# EPC DPW Stormwater\_2026-06-10\_007 - Drainage Report Markup Summary

**LOCATED AT  
BENT GRASS MEADOWS I  
IN EL PASO COUNTY, CC**

PCD File No. PPR2615

**PRIMARY DRAINAGE  
EOD**

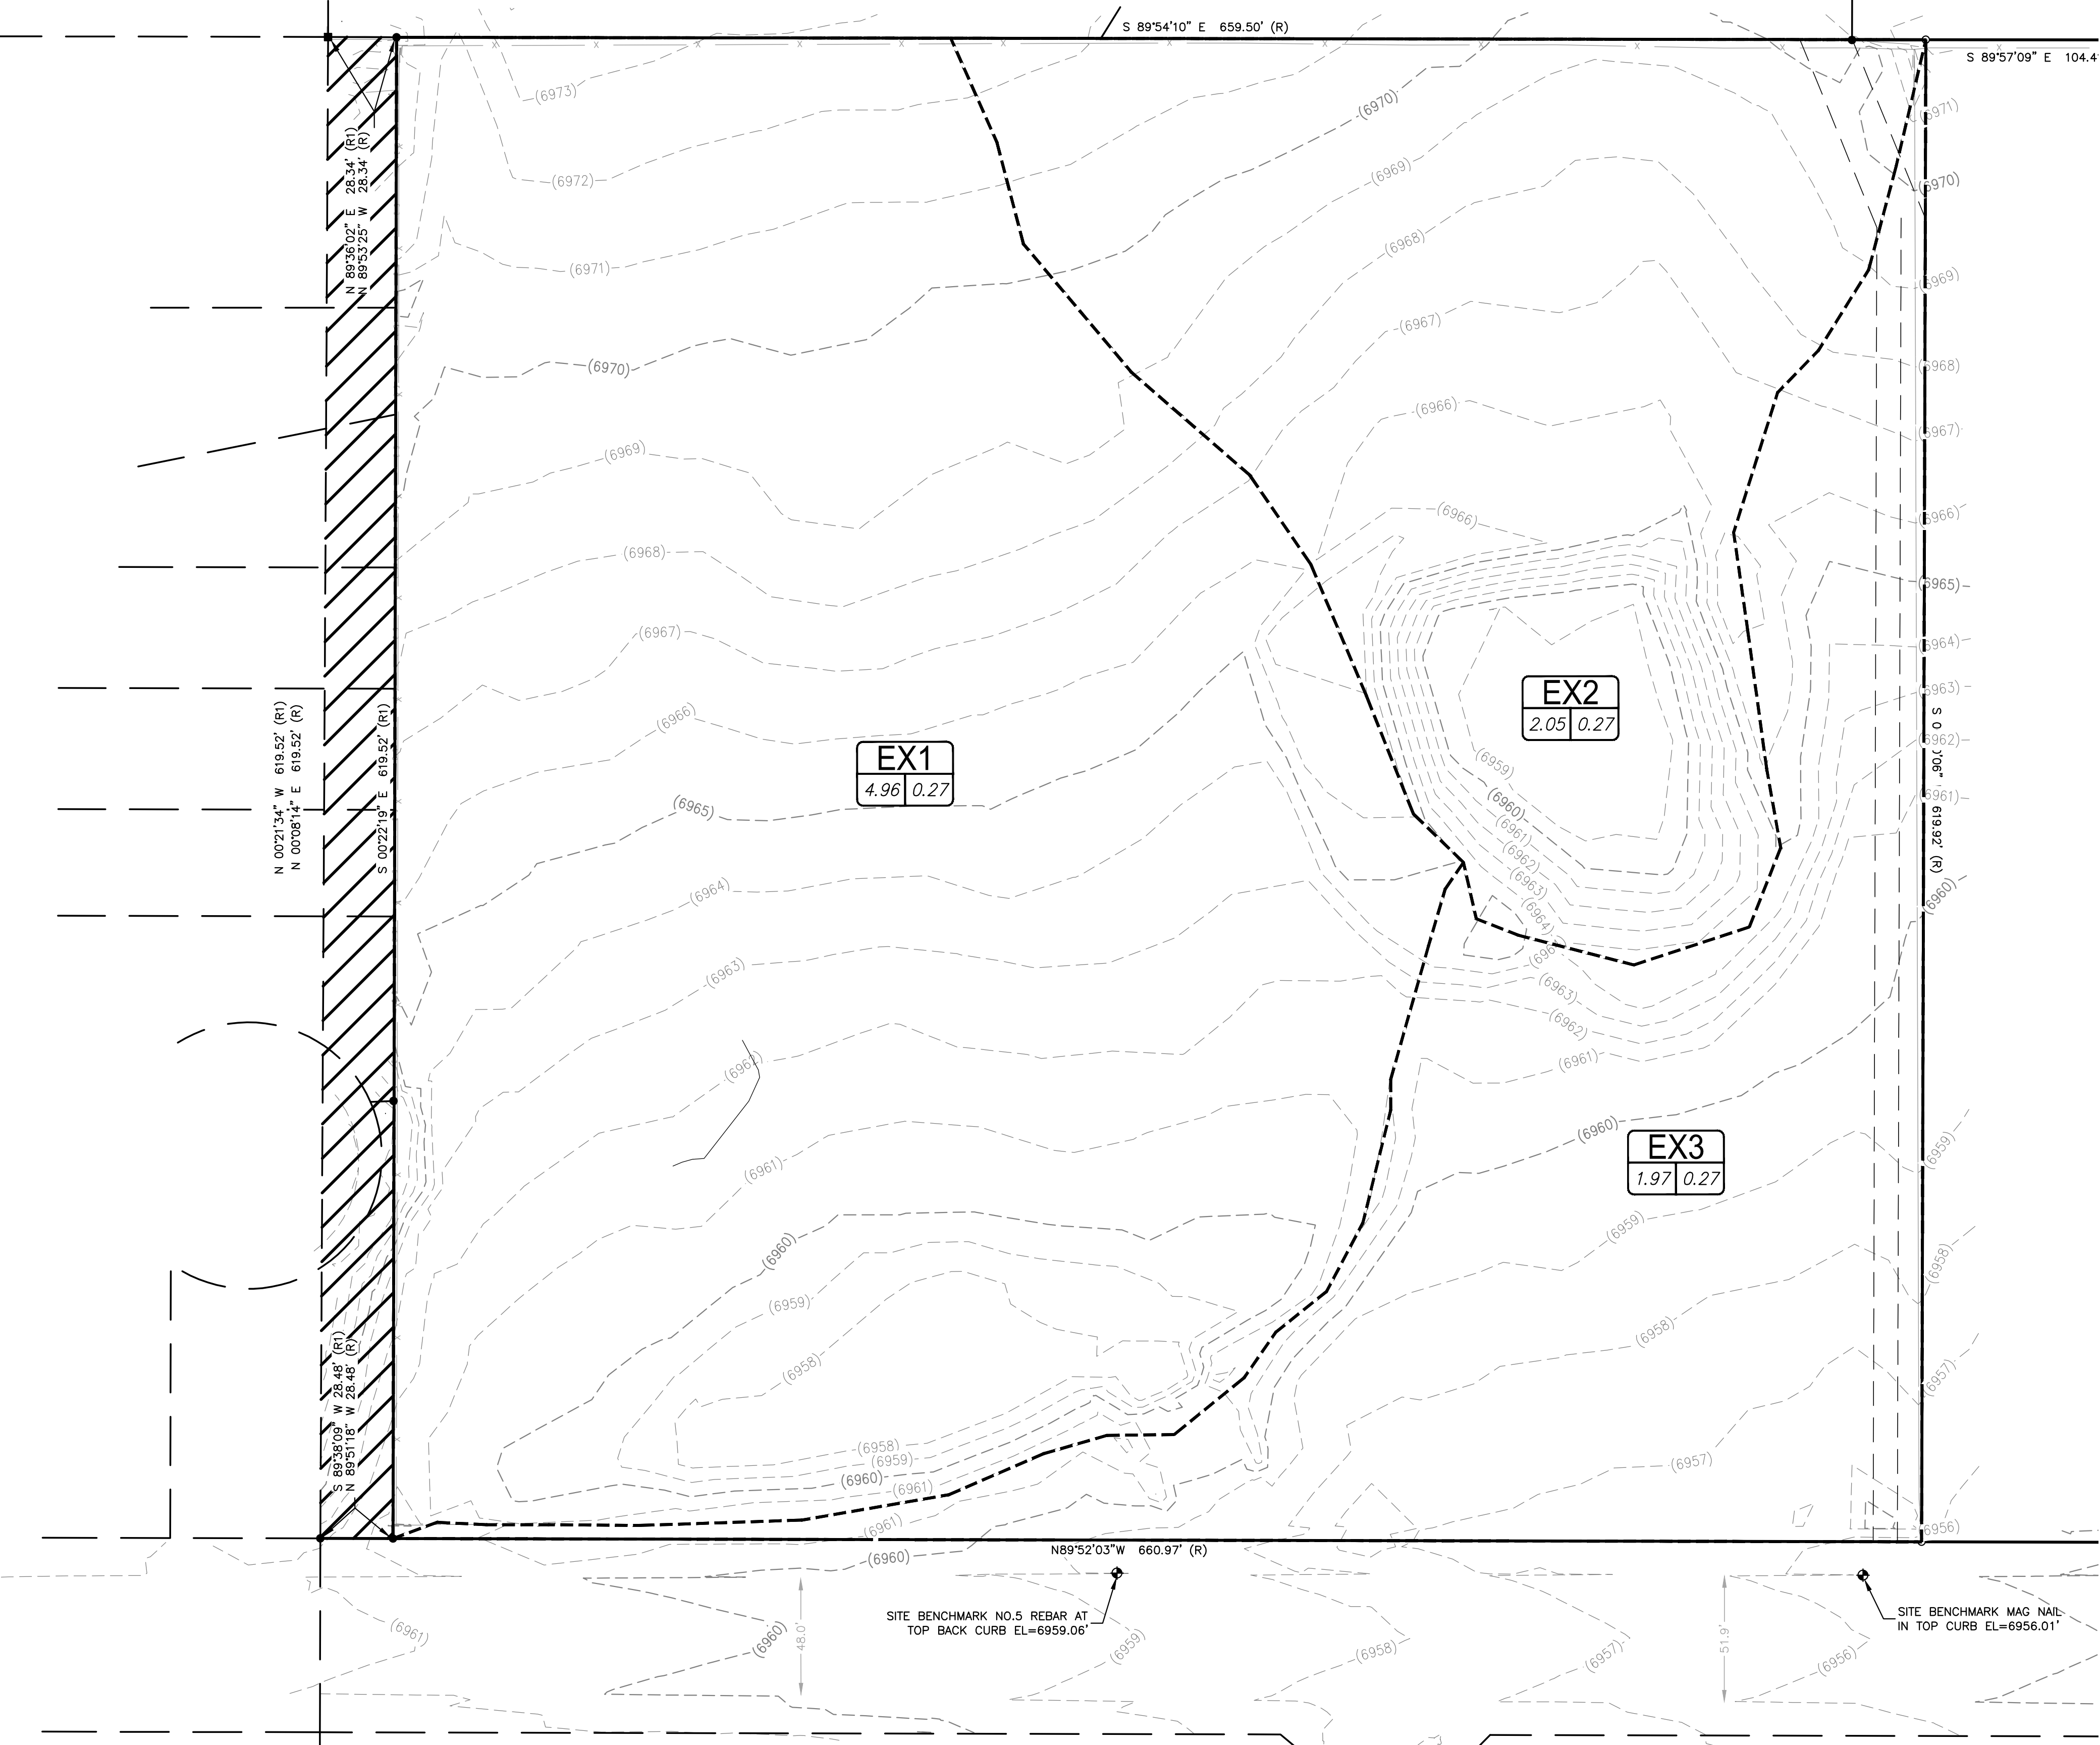
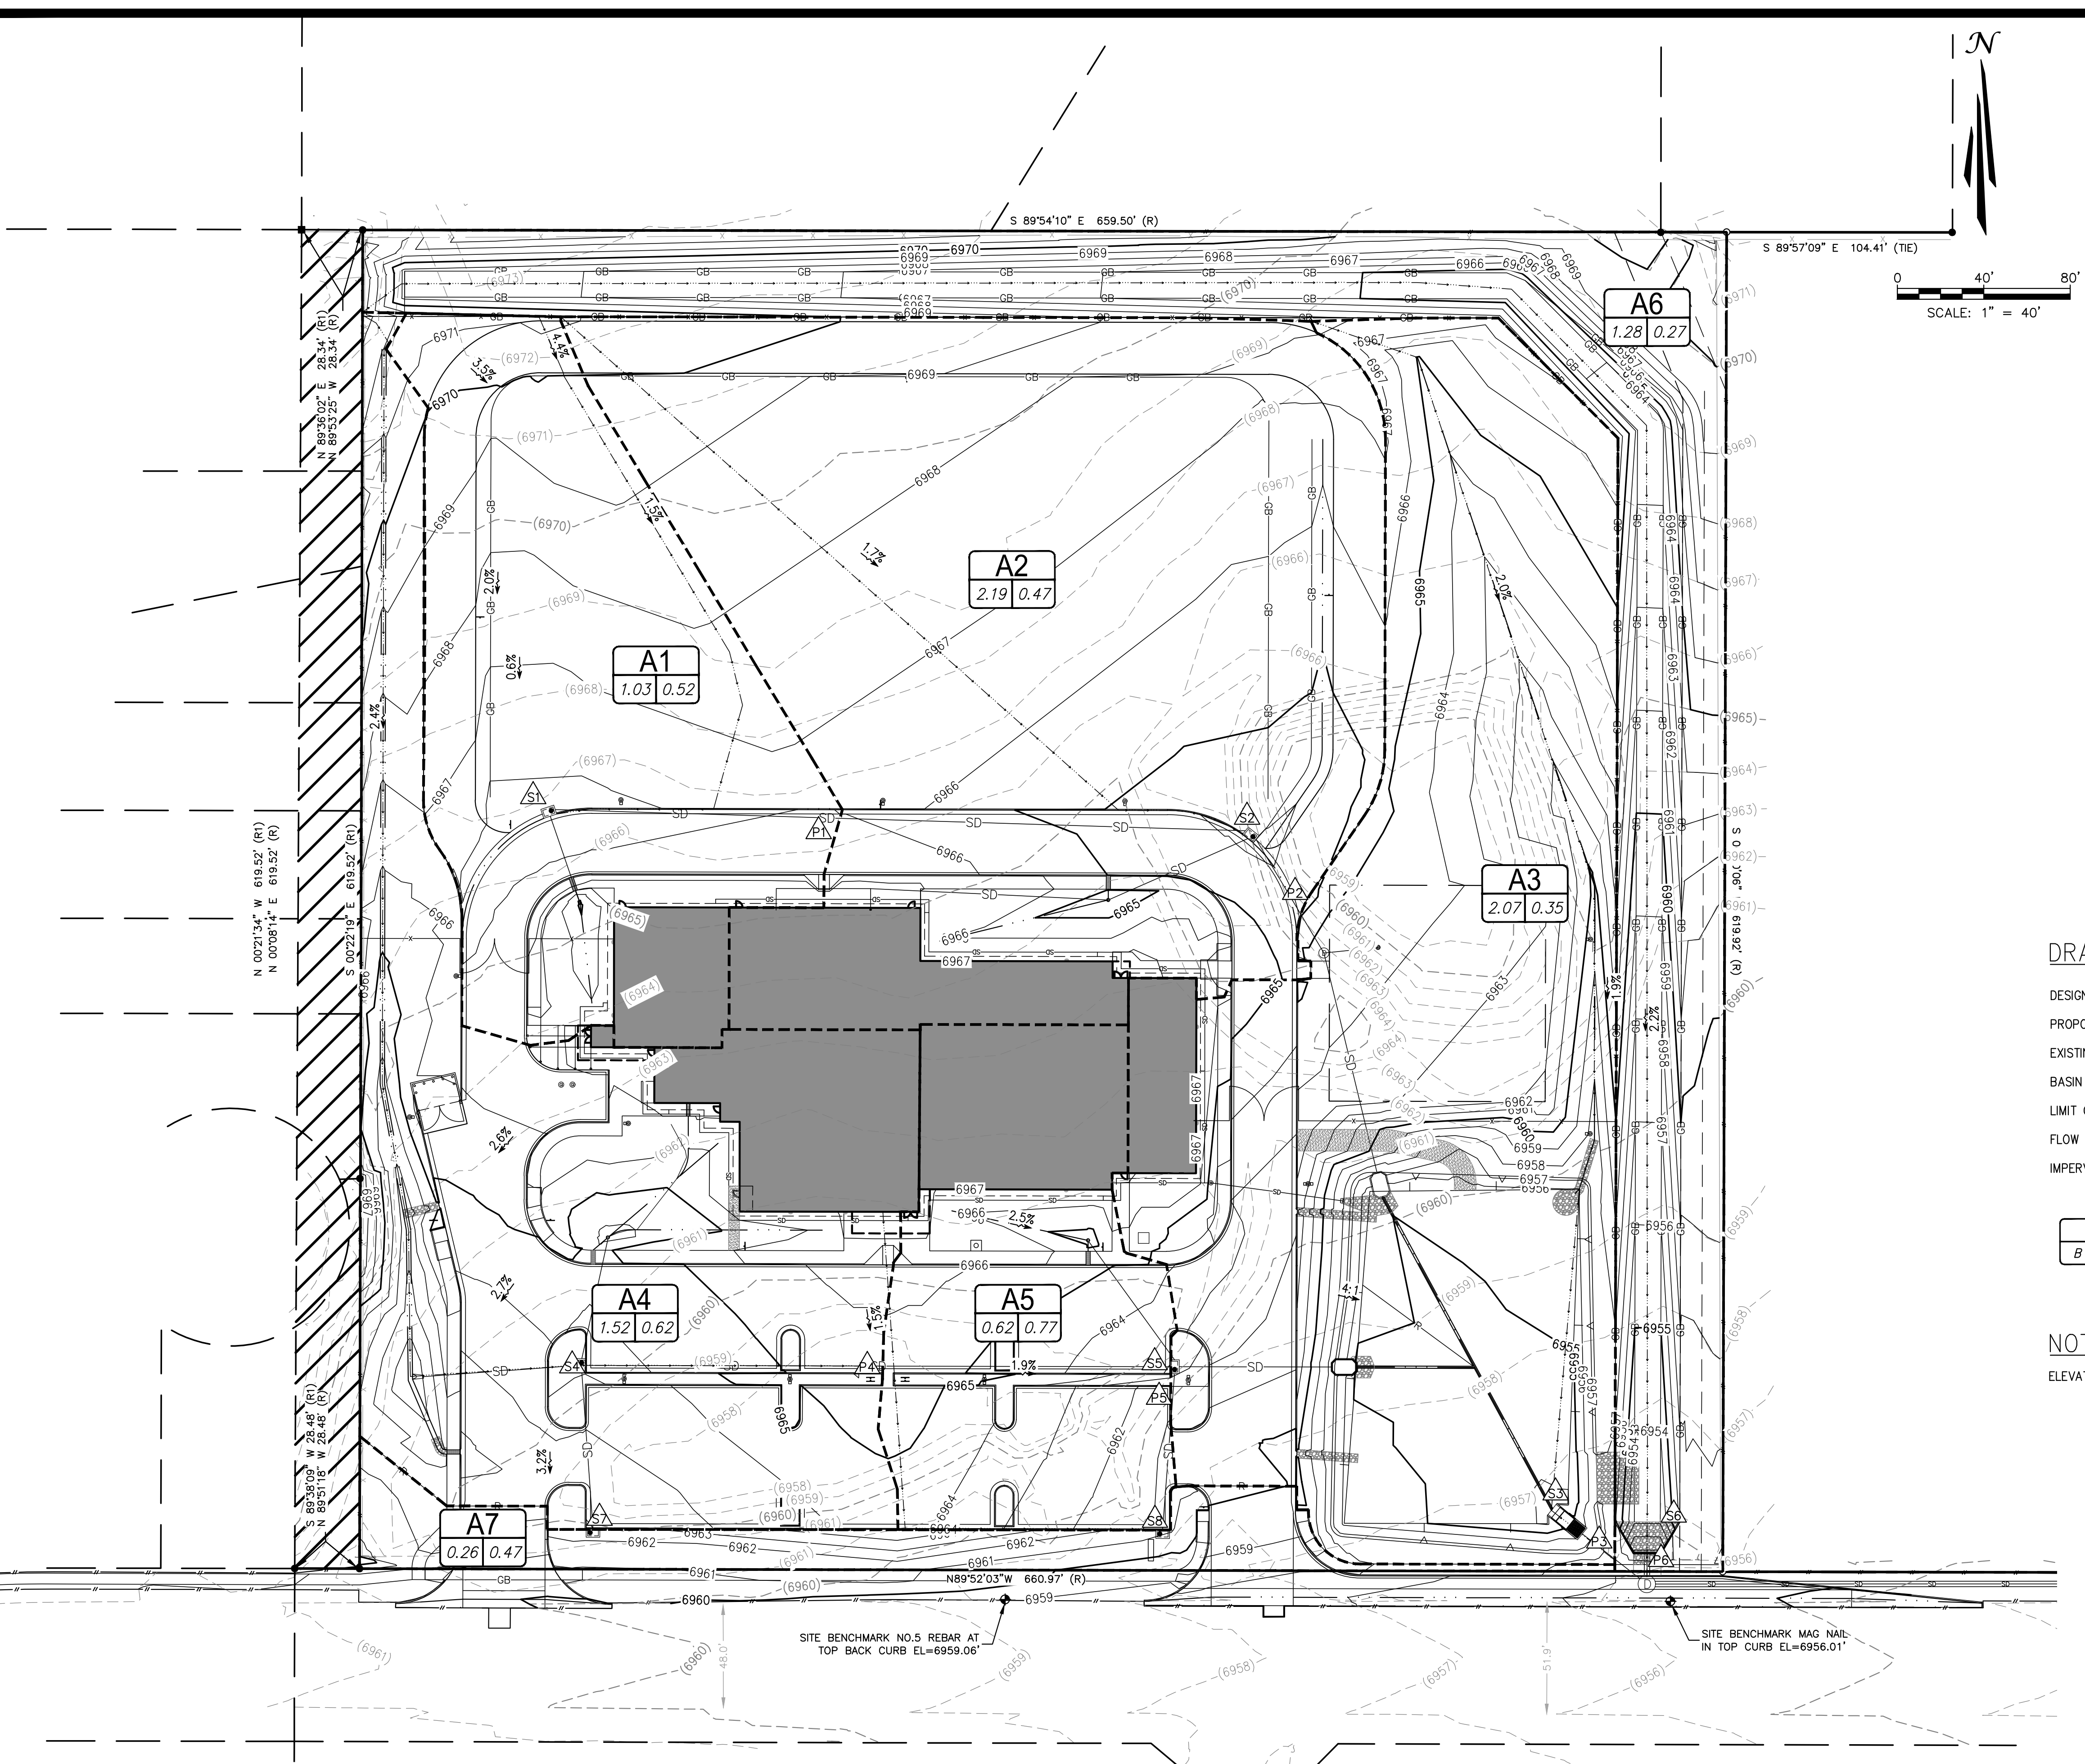
confirm DP2, maps shows DP1

please discuss the riprap rundowns shown on the map

**RESPONSE: NOTED**

**RESPONSE: DESCRIPTION ADDED**

100-year Emergency Overflow Detention Pond

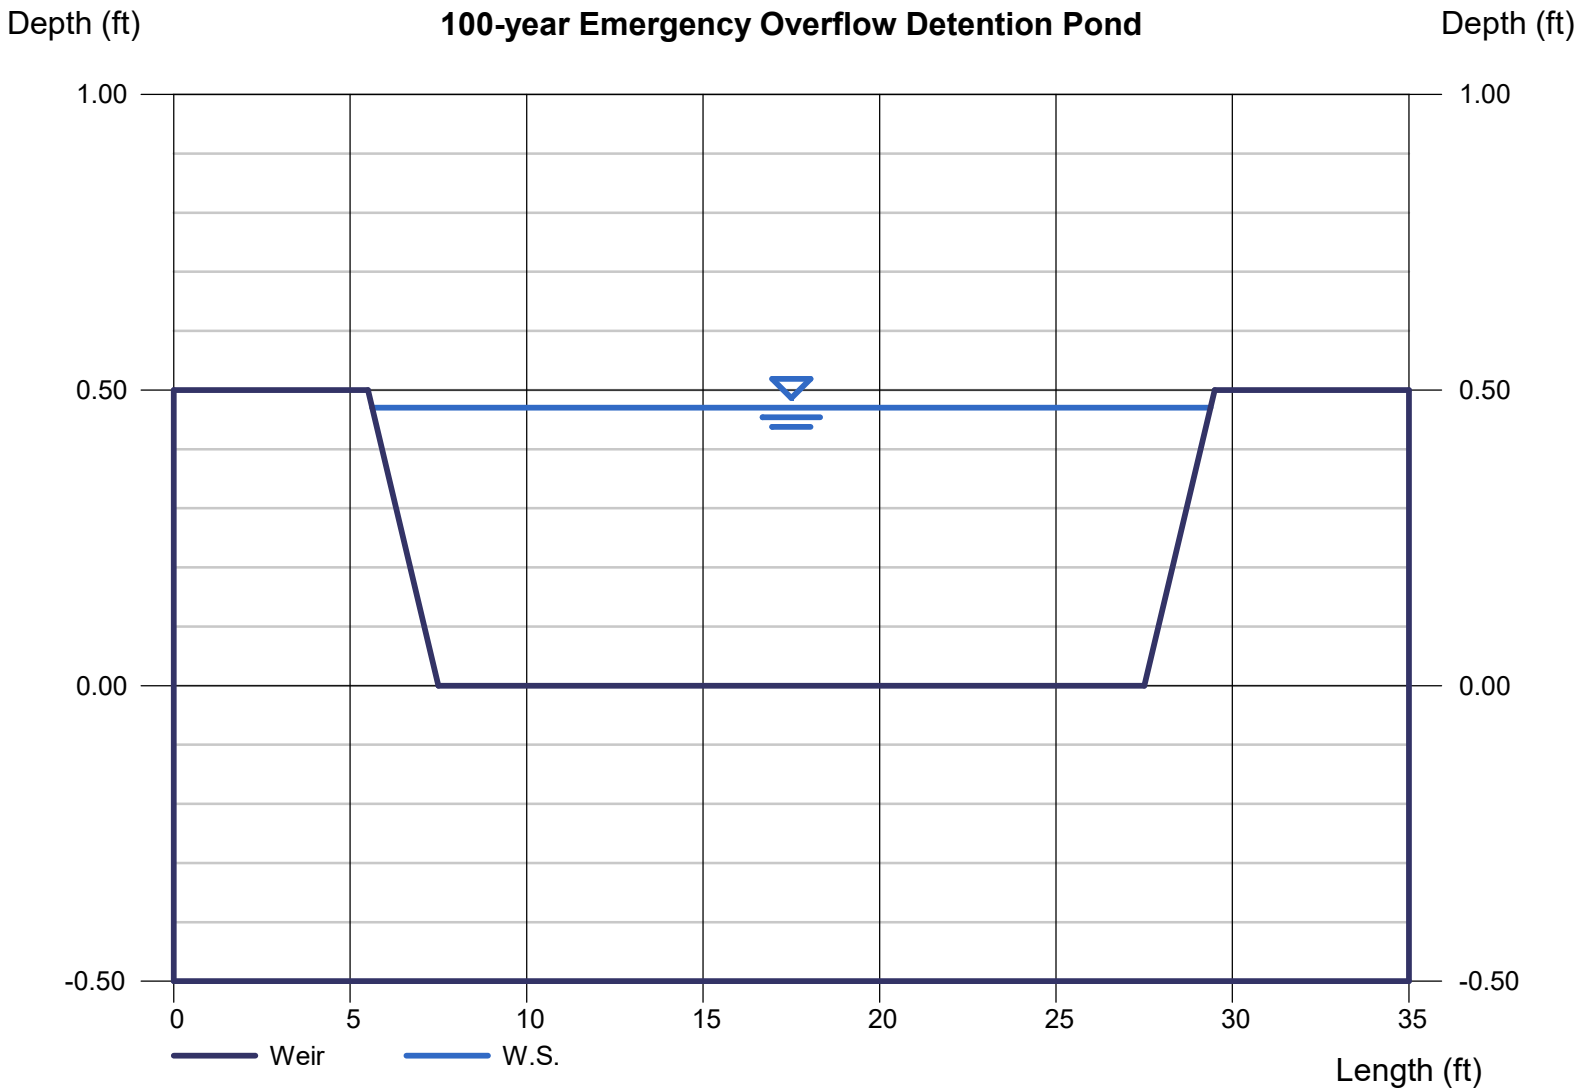
please describe the overflow  
path

Calcs unclear on when spillway  
is activated

**RESPONSE: OVERFLOW PATH  
DESCRIPTION ADDED**

**RESPONSE: CLARIFICATION ADDED**

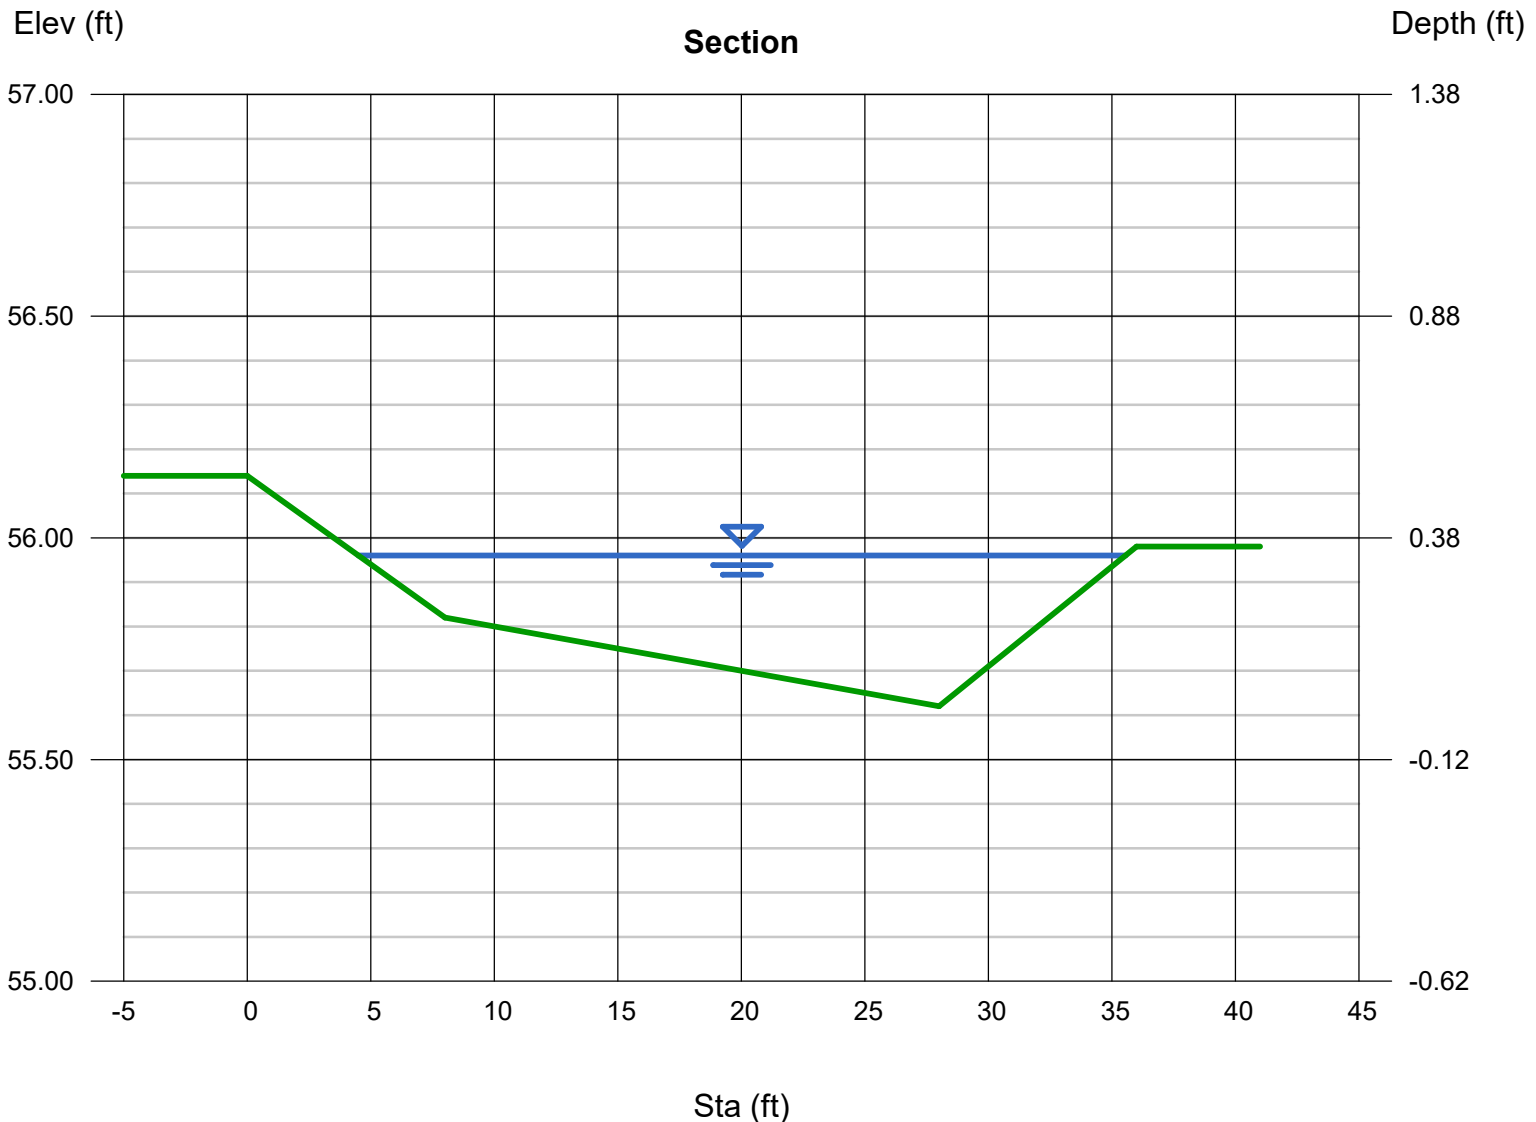
please include a statement that  
the roadway can accept this  
volume of flow per DCM Table  
6-1

**RESPONSE: ANALYSIS PROVIDED PER  
MEETING WITH COUNTY**
